Subject: APPLICATION 22/00499/DISC THE STABLES MAIN STREET GREAT BOURTON OX17 1QU

APPLICATION 22/00499/DISC CONDITION 5
THE STABLES MAIN STREET GREAT BOURTON OX17 1QU (APPEAL REF:
APP/C/3105/C/21/3268454

# SITE LAYOUT PLAN

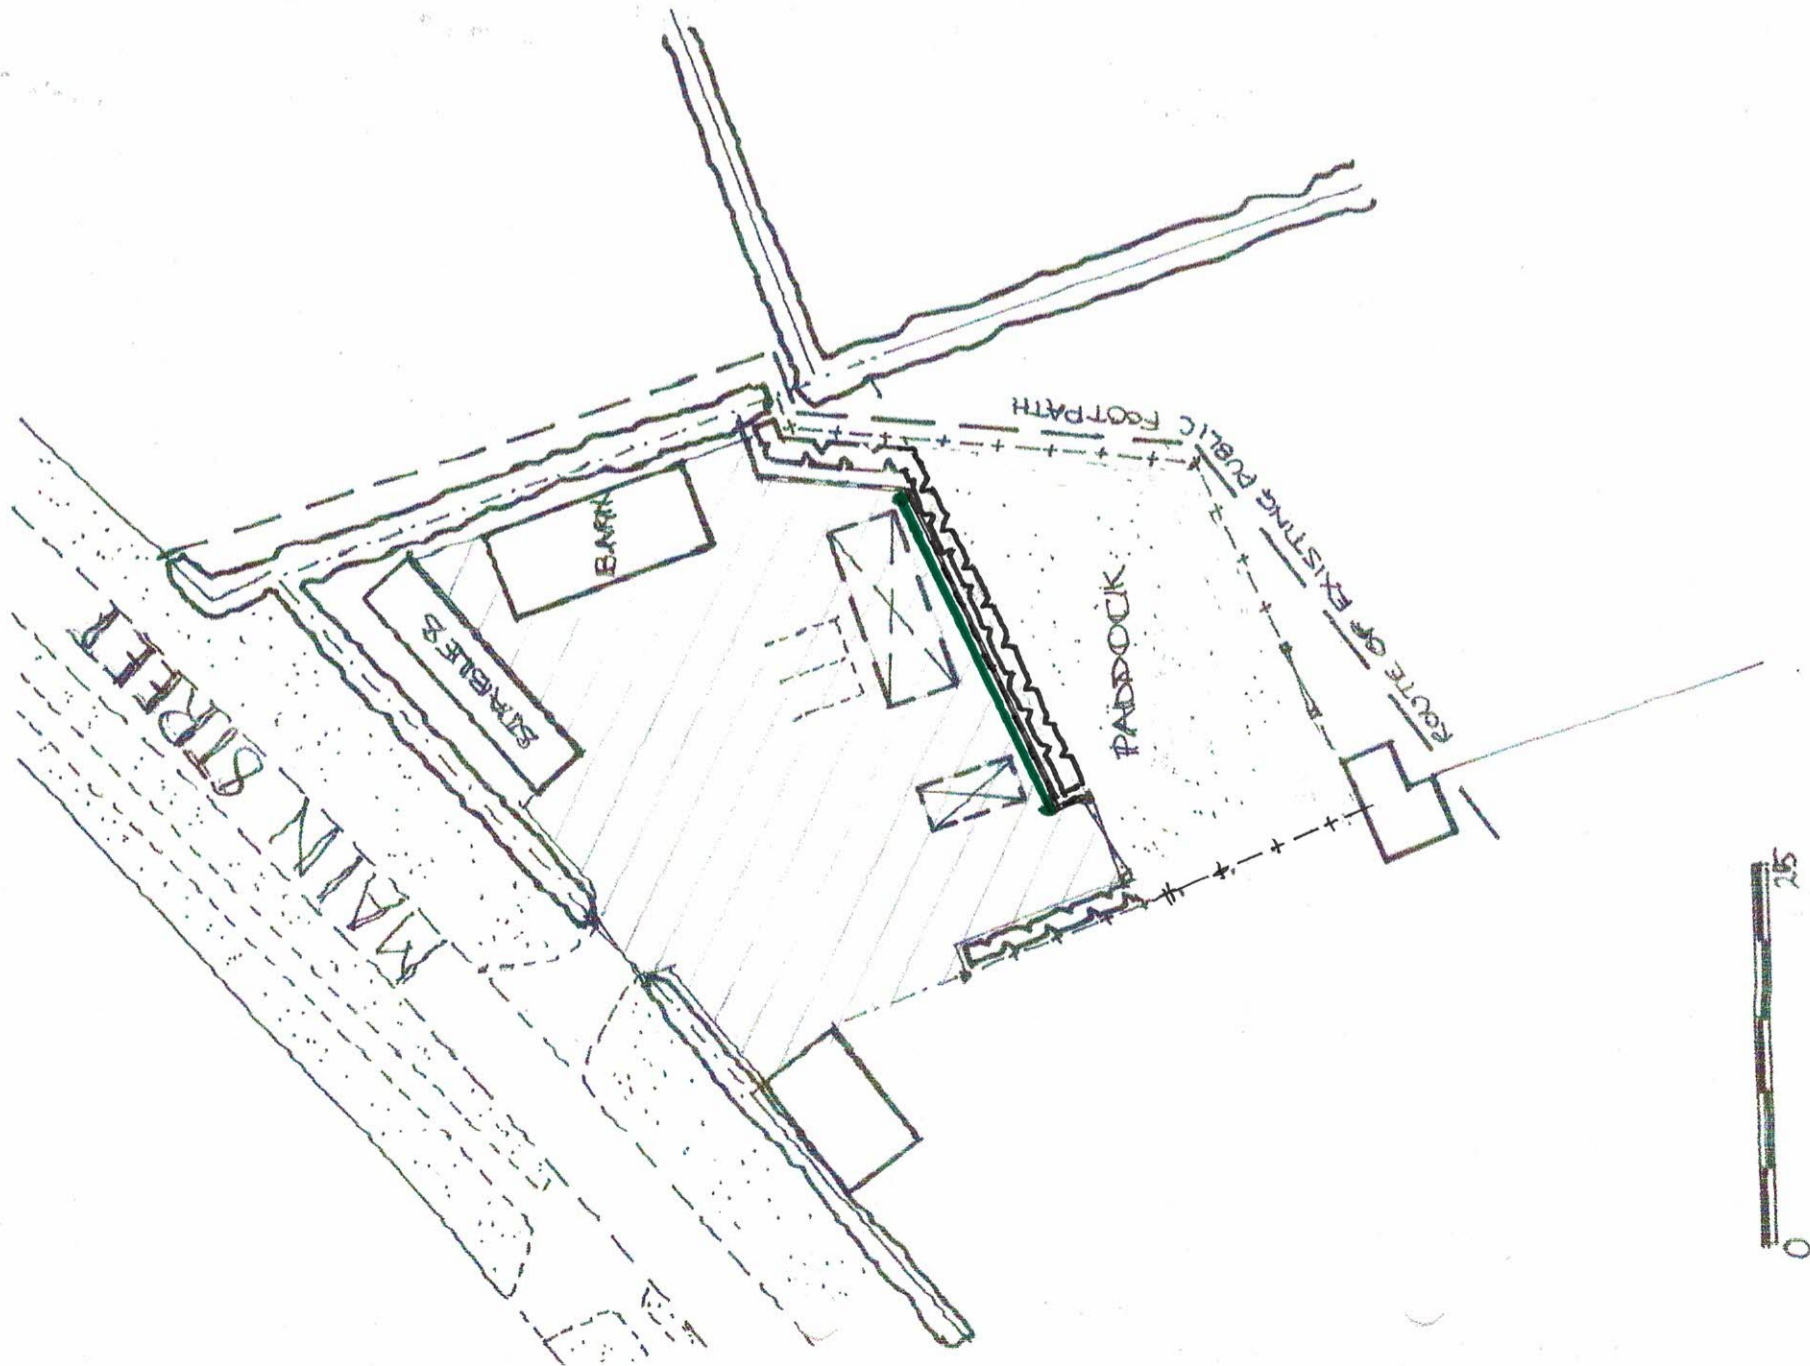
I note that the Site Plan shows the two pitches marked much further back onto the grassed field area and the applicant has already had many more lorry loads of hardcore dumped onto the grassed area since the Appeal approval, much of which he has already levelled, therefore making a large extension to the existing hardcore area despite indicating on the application form that "No work has yet begun" - it most definitely has! CDC have been alerted to this work by members of the public including myself and Bourtons Parish Council as we are all very concerned at the laying of much more hardcore into the green field area and the further problems this will create. Therefore to safeguard adjacent land from flooding this hardcore should be removed.

I do not believe that there is enough fall to connect to the main sewer across the road as indicated. Also any on site sewage treatment plant would not work on this low lying impermeable land as any discharges would enter the ditch which flows through the grounds of Cropredy School and end up in the Oxford Canal.

The site plan shows a dog leg diversion to the line of the Public Footpath that crosses the fenced off area of the application site but this is incorrect and leads one to believe the footpath does not go through the fenced off area of the site. OCC Fieldpath Officers are not allowing the diversion as shown on the plan. Because of so much previous dumping in the field and the land being no longer to able drain it is in flood throughout the winter making the path difficult to walk.
